PROJECT NO.	1002125	APPLICATION NO.	02 - 01611
PROJECT NAME	Reynolds Add.		
EPC APPLICATION NO.			
APPLICANT / AGENT	Kevin Georges	PHONE NO.	255-4975
ZONE ATLAS PAGE

DEVELOPMENT REVIEW BOARD TRANSPORTATION DEVELOPMENT Standard Comment Sheet

Re: Addition for St. Vincent de Paul Society
1313 Iron Avenue SW
Albuquerque, New Mexico

EPC Case No: 02EPC - 01157 SDP - Building Permit.

Site Plan - Phase 2
1"=20'

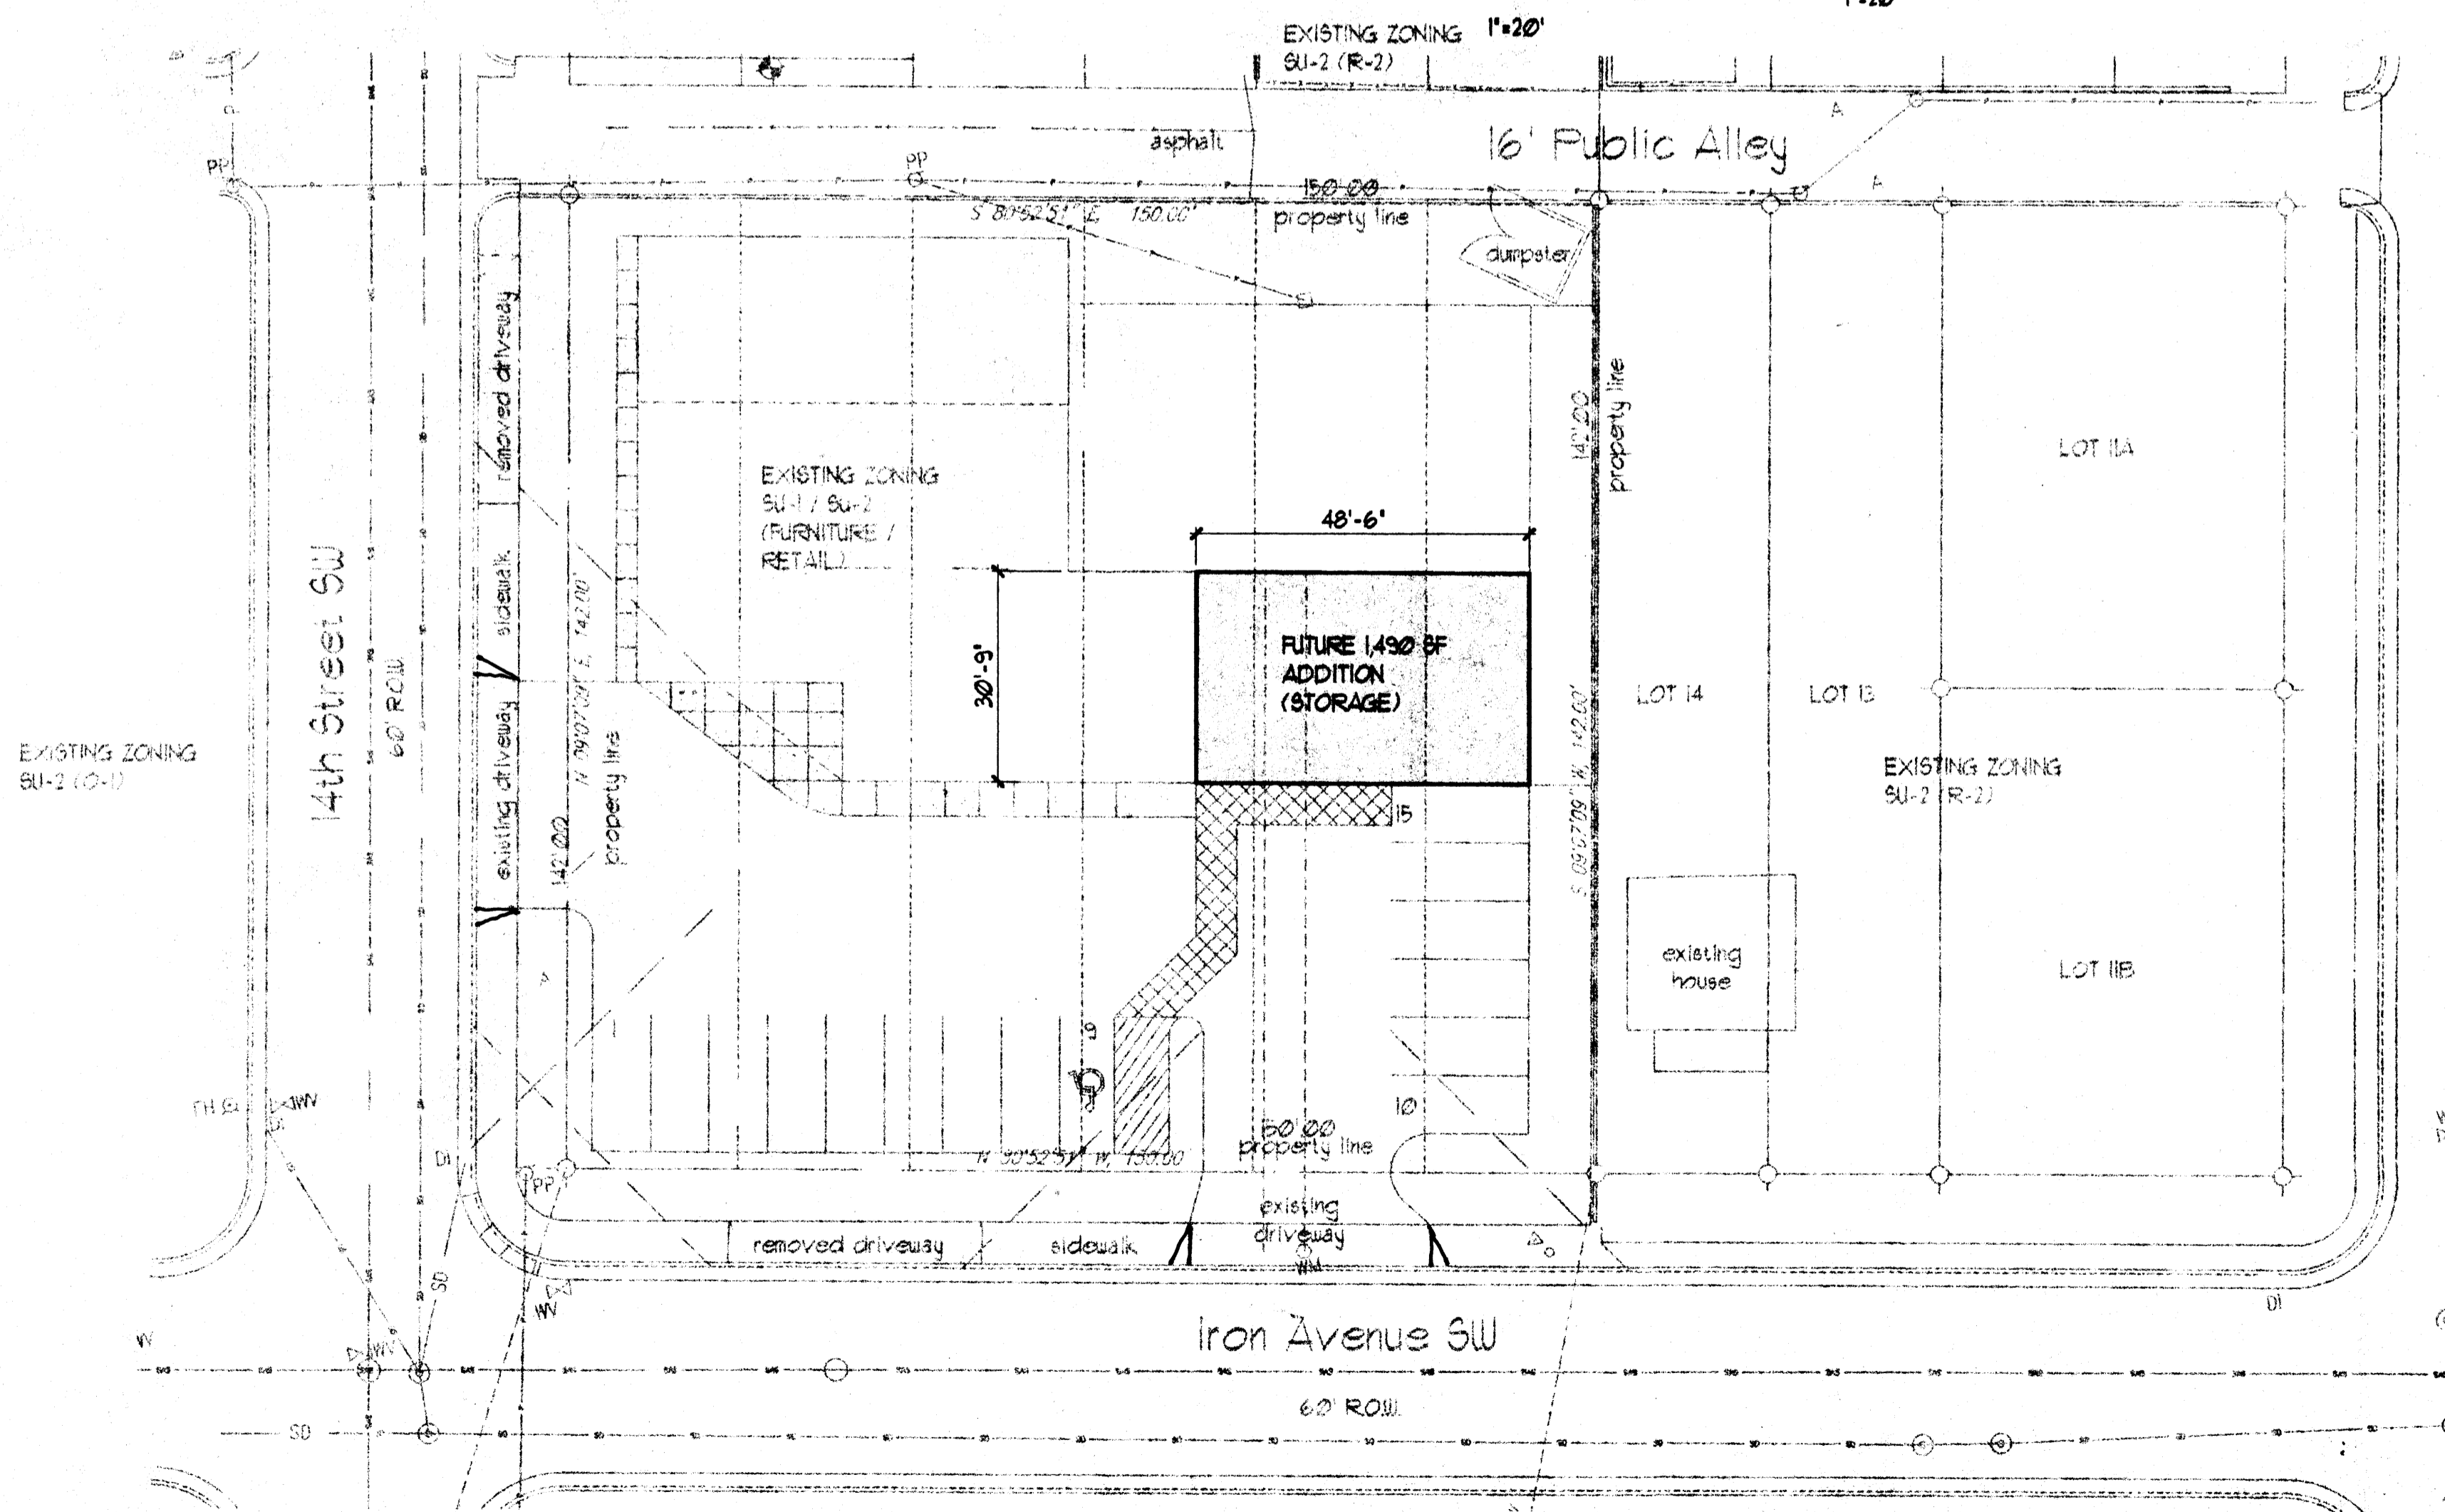
No.	Comment
<input type="checkbox"/>	The entrances appear to be shown incorrectly, distorting the access points.
<input type="checkbox"/>	The driveway on 14 th Street being closed, will need to be replaced with curb and gutter along with a new 6ft sidewalk.

- A. The Developer is responsible for permanent improvements to the Transportation Facilities adjacent to the proposed Site Development Plan. See Items B, C, & D. (Paving, curb, gutter and sidewalk are existing).

- B. An ADA accessible ramp will be constructed at the northeast corner of 14th and Iron. See C3.
 - C. Site work complies with DPM standards.
 - D. Driveway at alley to 14th Street to be made ADA accessible. See C3.

SHEET TITLE: **CONCEPTUAL GRADING PLAN**
 SHEET NO: **C3**

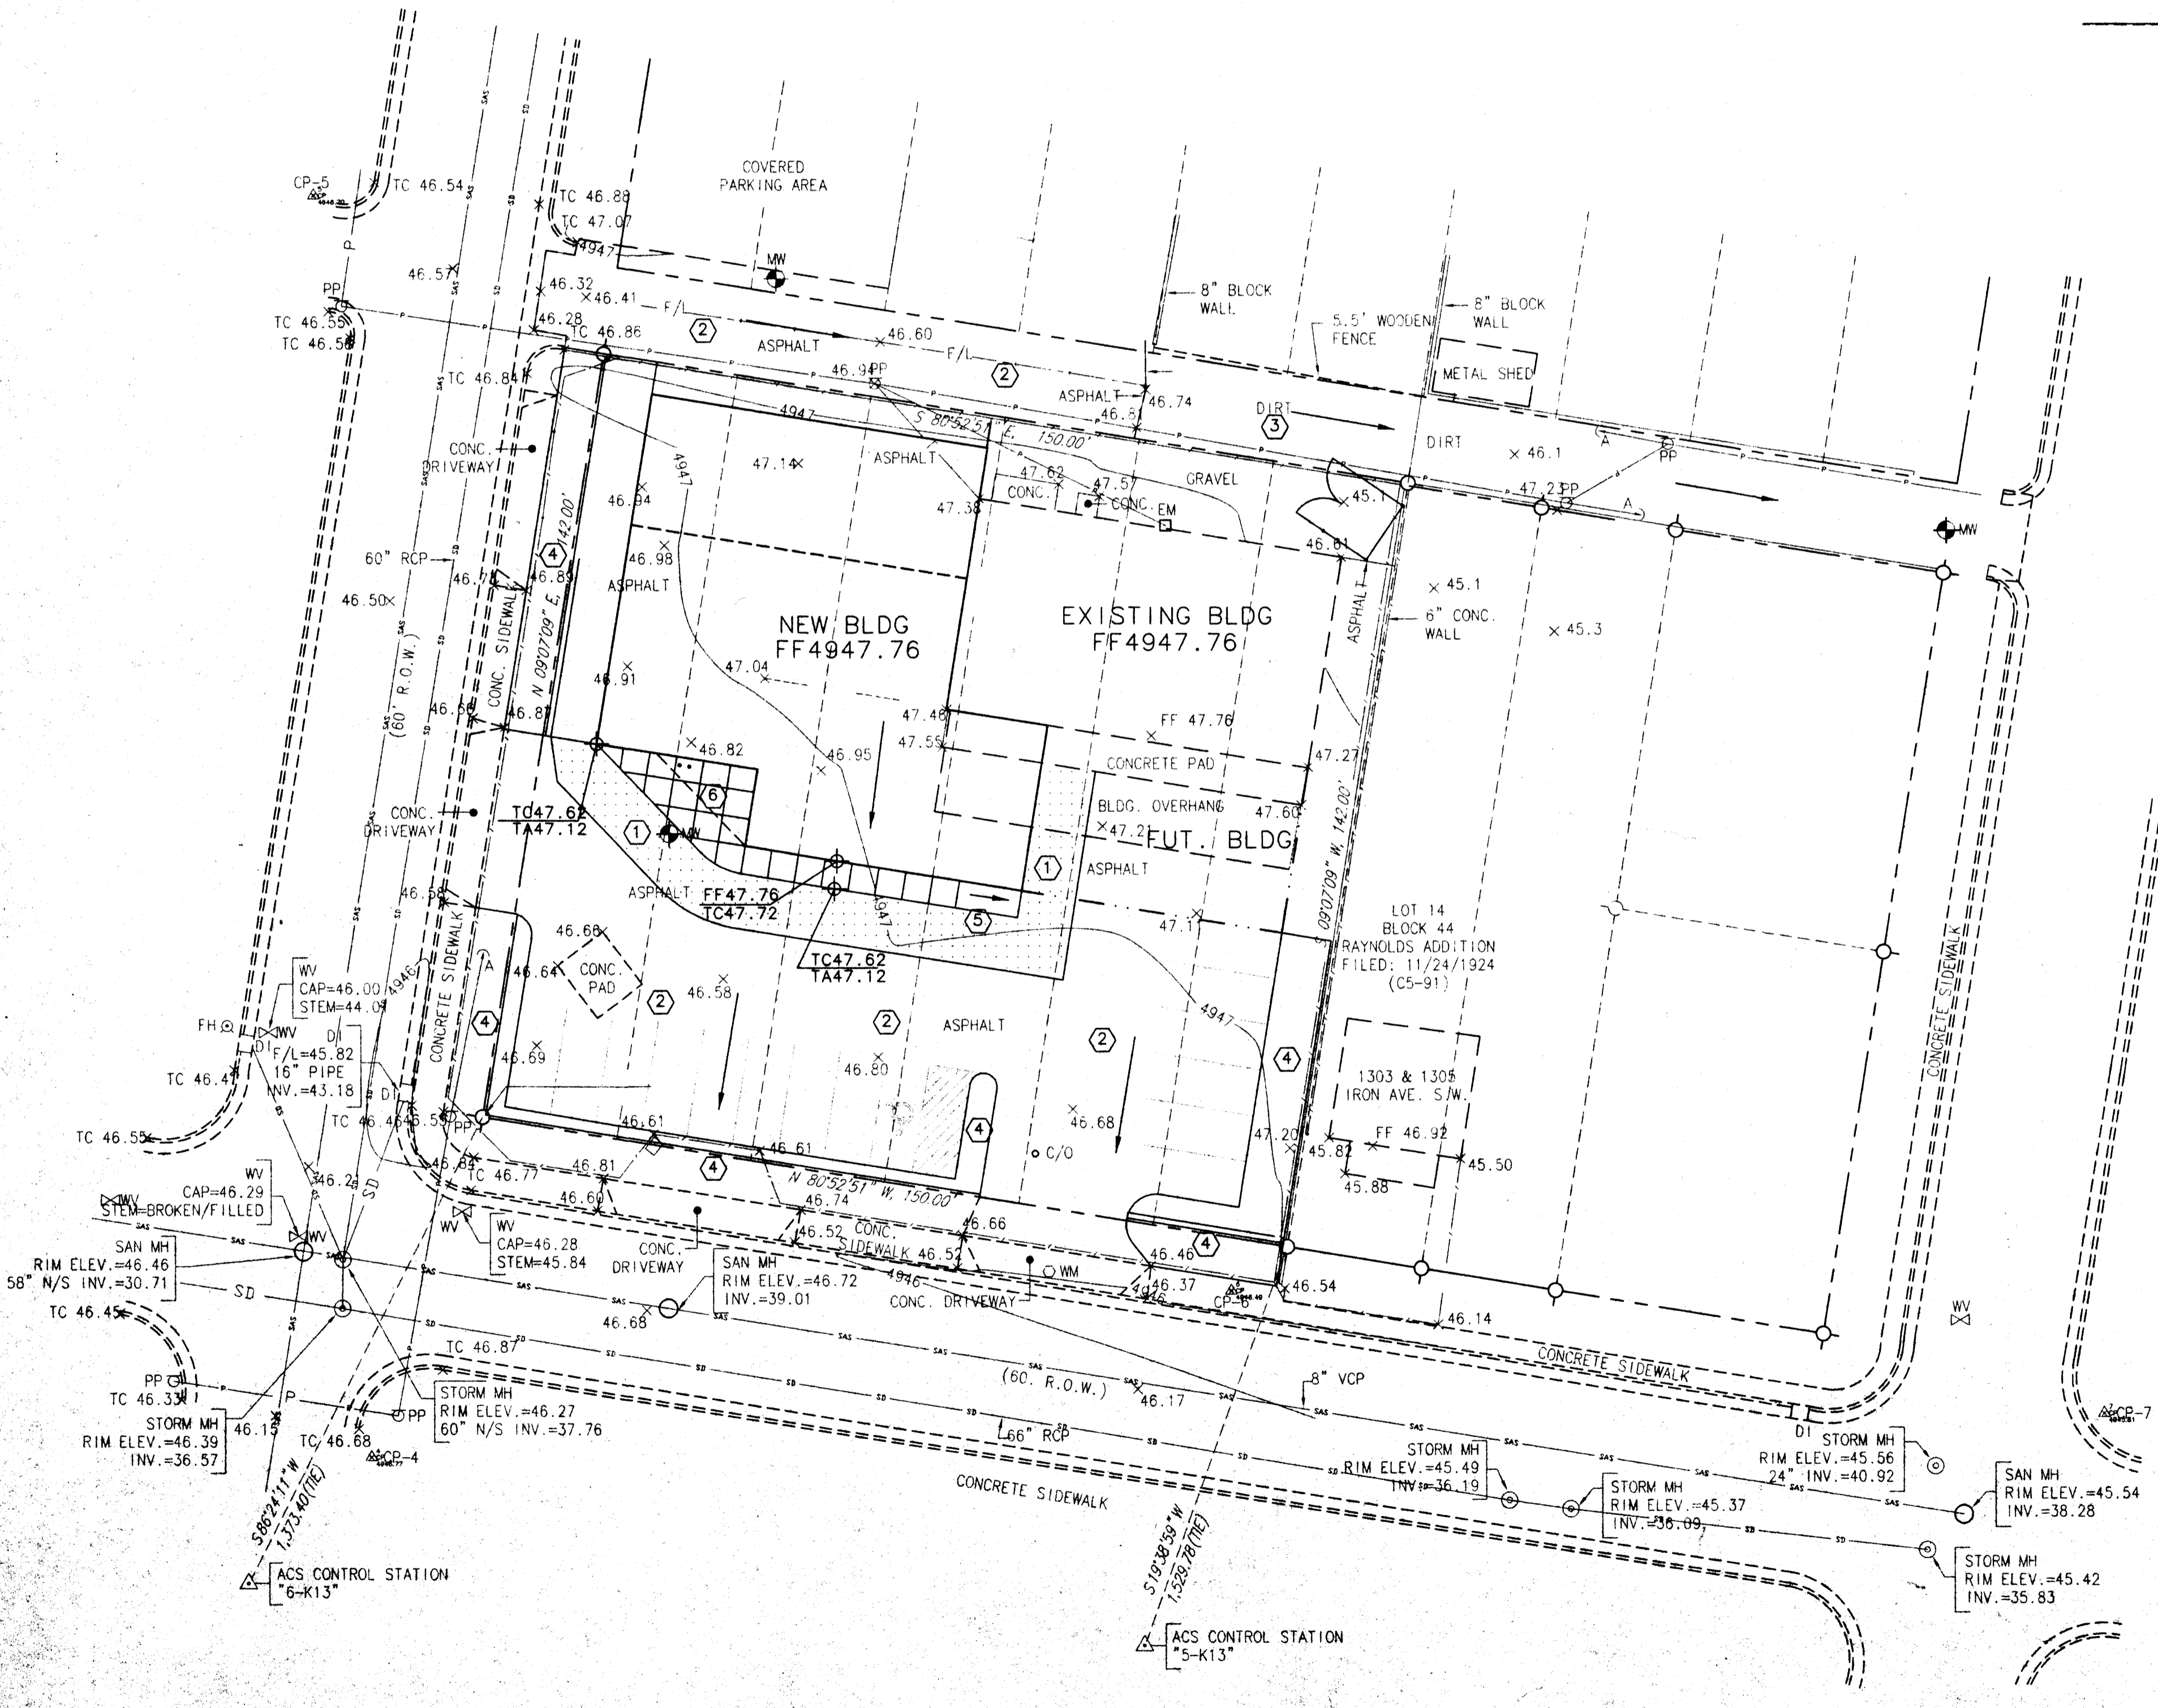
1. The Floodplain Ordinance indicates that the finish floor needs to be elevated one foot above the floodplain. Your report indicates that this is not the case. I would suggest taking a cross section around the center of the building. Also, address how the 66-inch storm drain affects the FIRM floodplain. Please copy the 100-year floodplain from the FIRM drawings on to your drawing.
2. Call out the monitoring well symbol in the legend. Where is the roofline in relation to the well at the front door of the building? There can be no obstructions to access the well.
3. It appears that your grading scheme intends to collect onsite runoff for landscaping. You may wish to provide sections, details, etc. as to how this is accomplished (recessed planting area, etc.)
4. Reference the vertical datum of the benchmark. It is either 1929 or 1988, please stipulate which.
